**Consultation Response from KC,
Lead Local Flood Authority**

2023/90024 George Hotel, St George's Square, Huddersfield, HD1 1JA

Date Responded: 14/02/2023

Title  
 DRAINAGE SURVEY

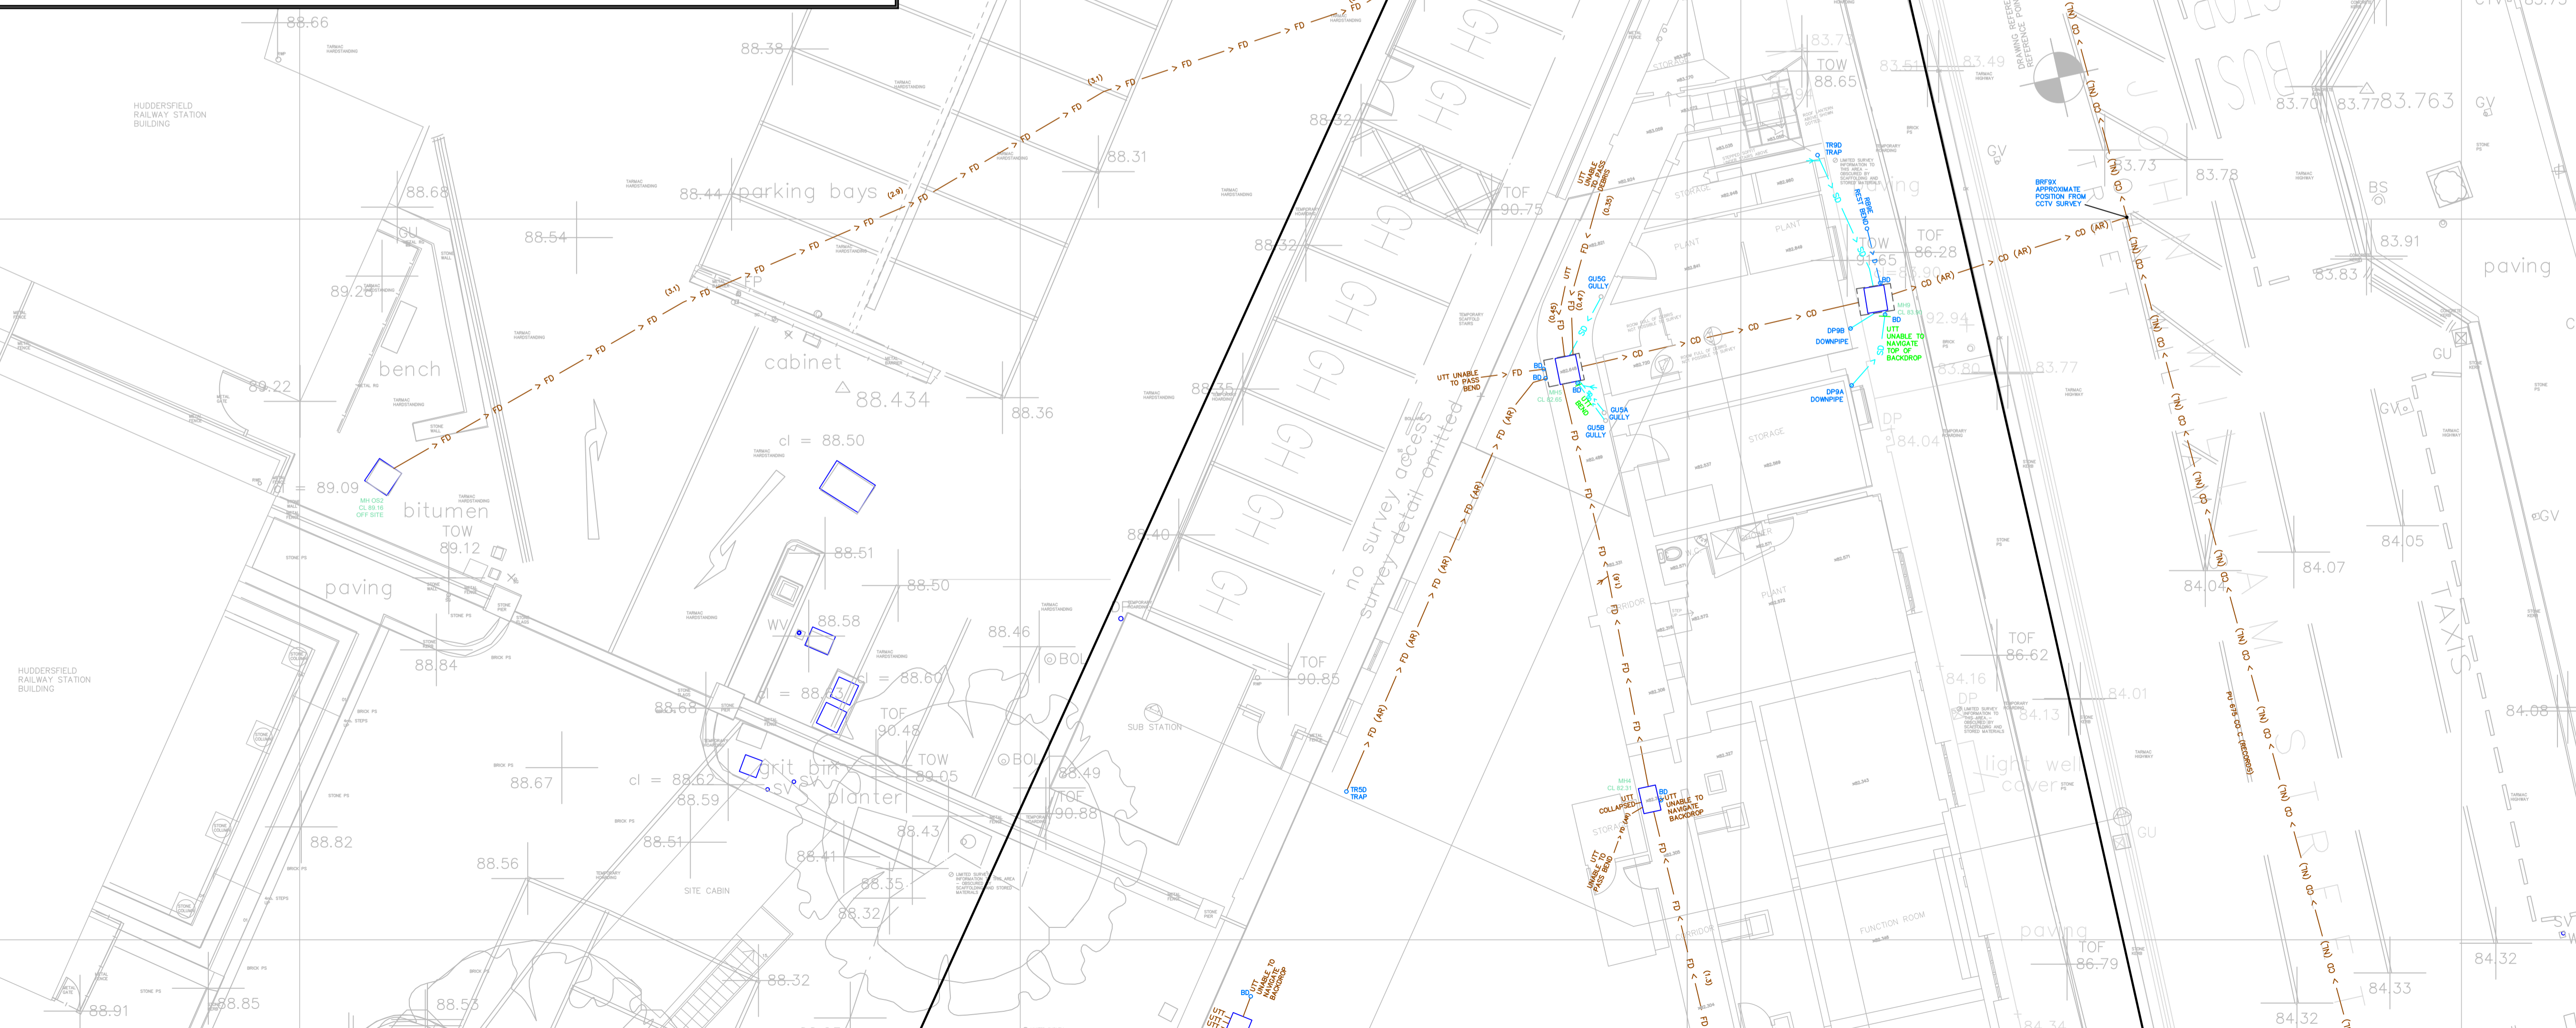
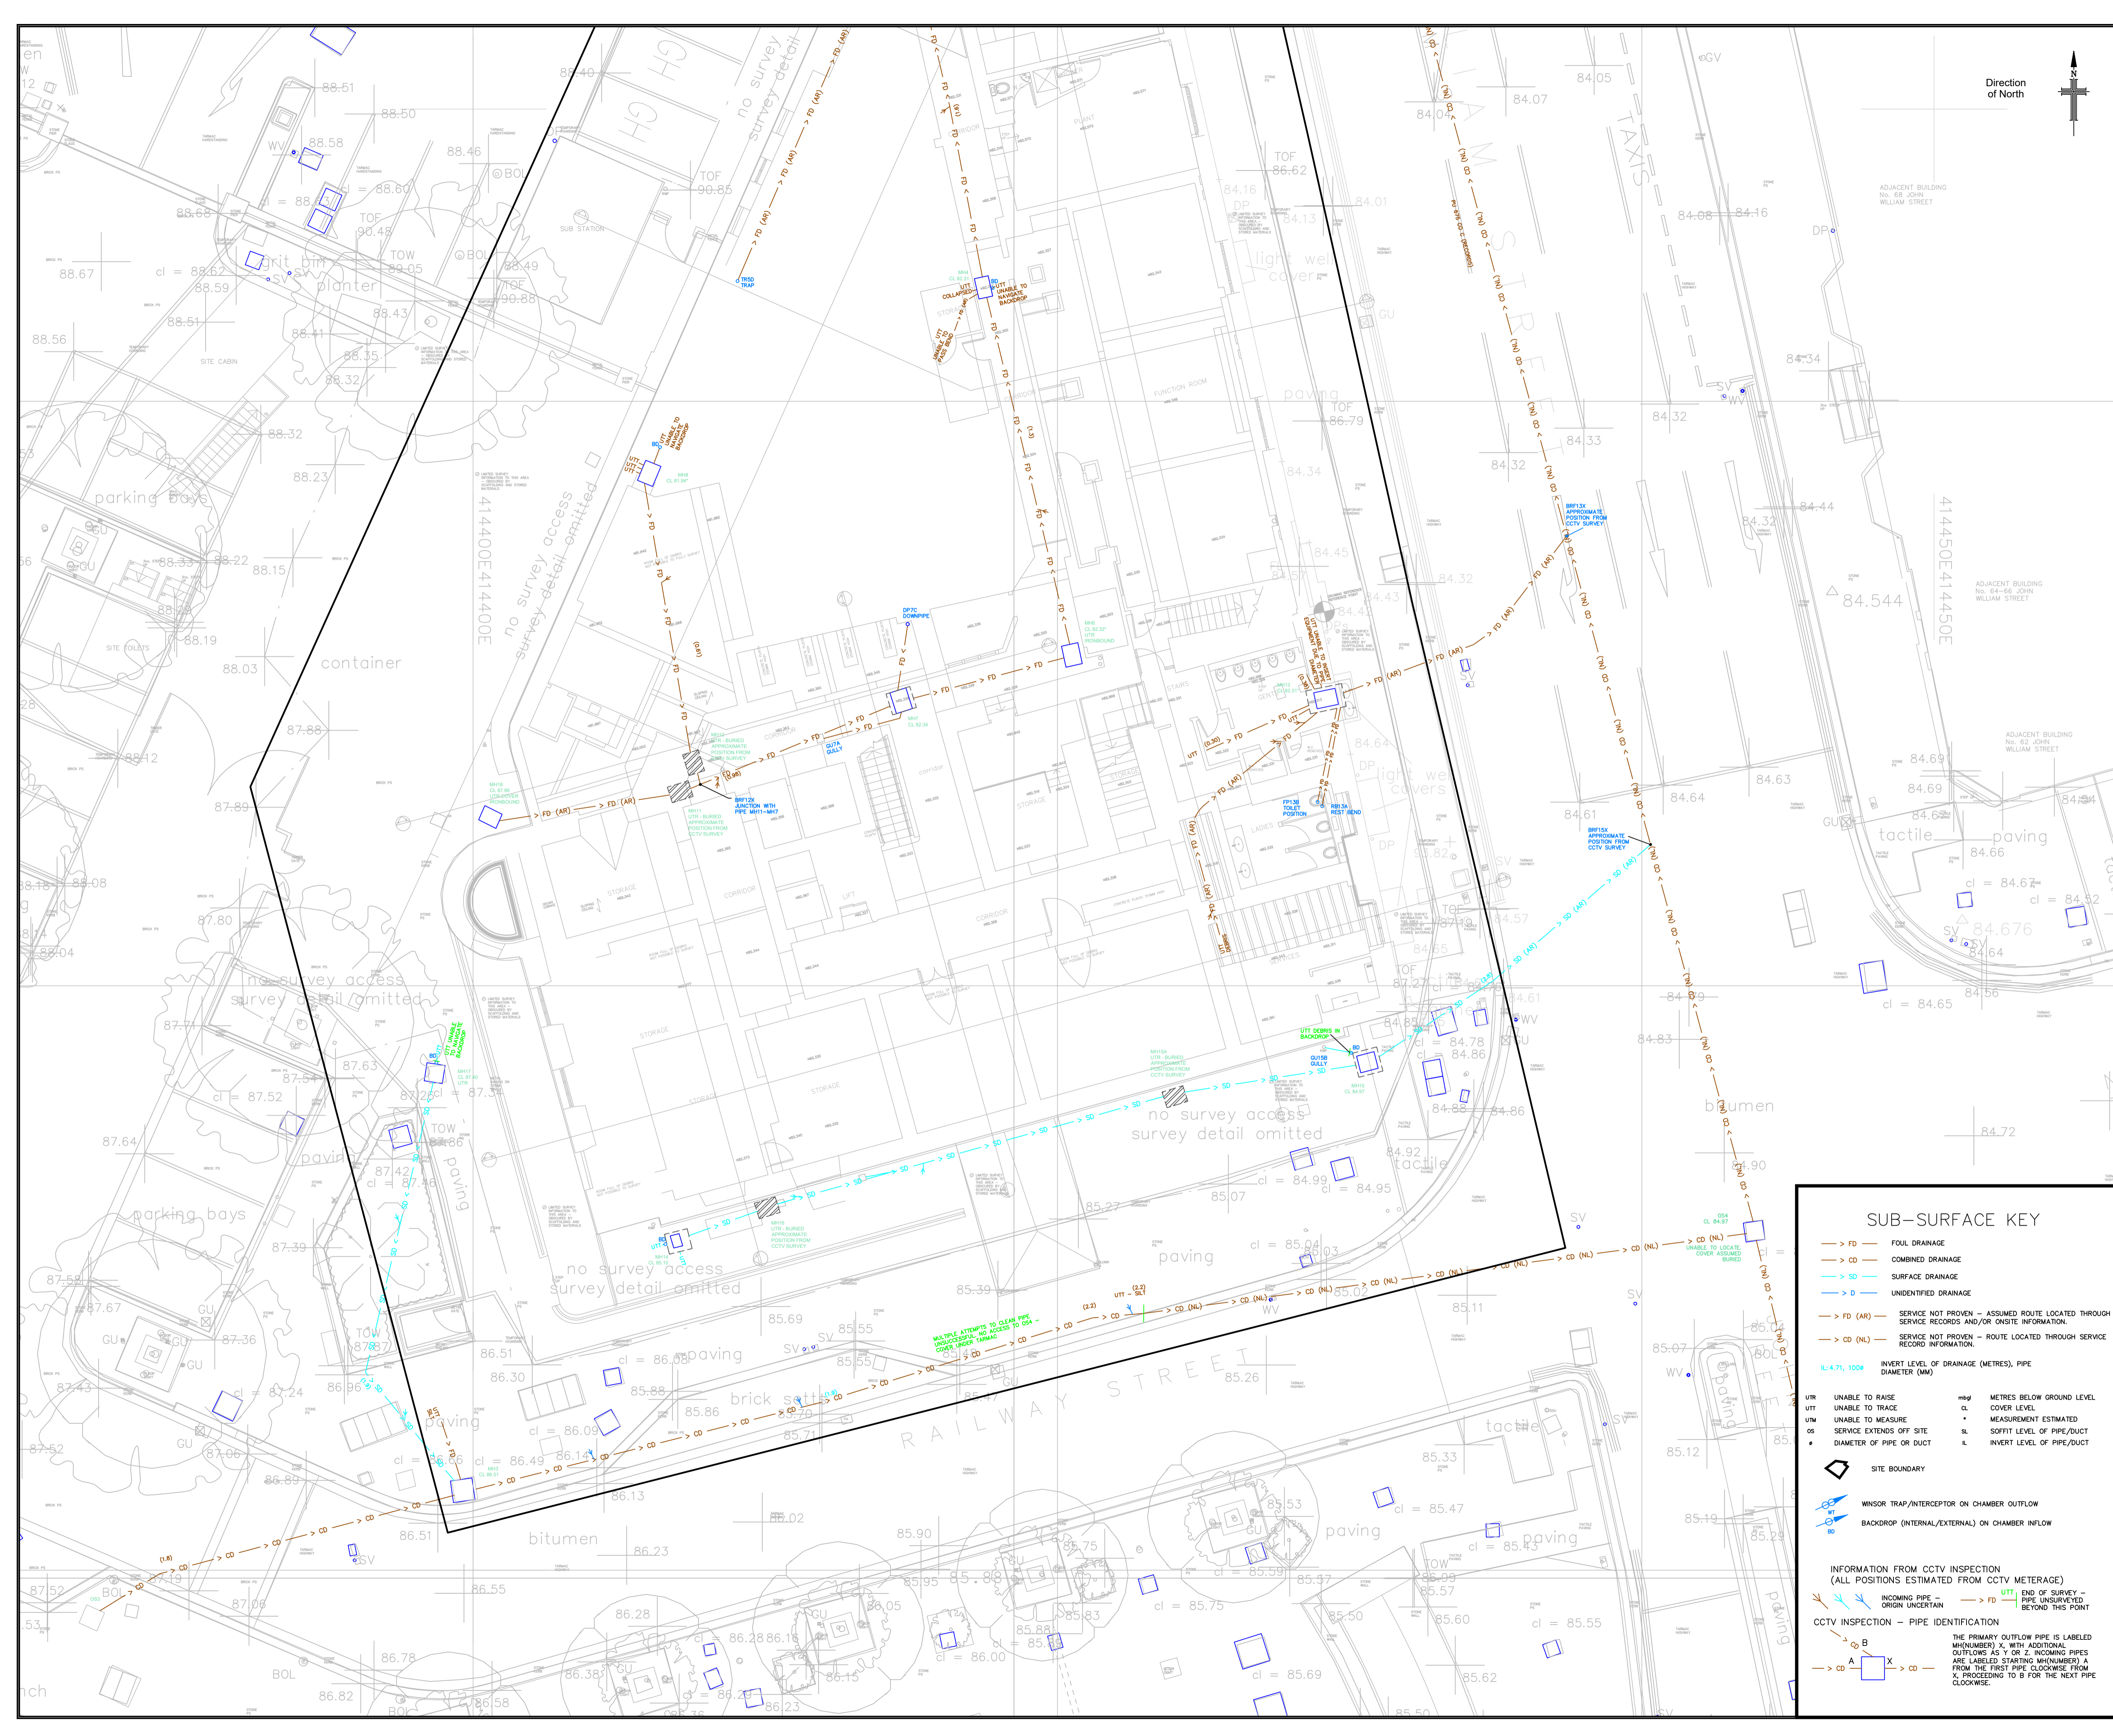
It is noted that in the Drainage Notes that the development will retain and re-use existing surface water drainage, which is shown by the MetGeo drainage survey (Appendix C) to discharge to the Public Combined Sewer adjacent to the building. Some additional connections to the public sewer are proposed and these will be subject to Yorkshire Water approvals.
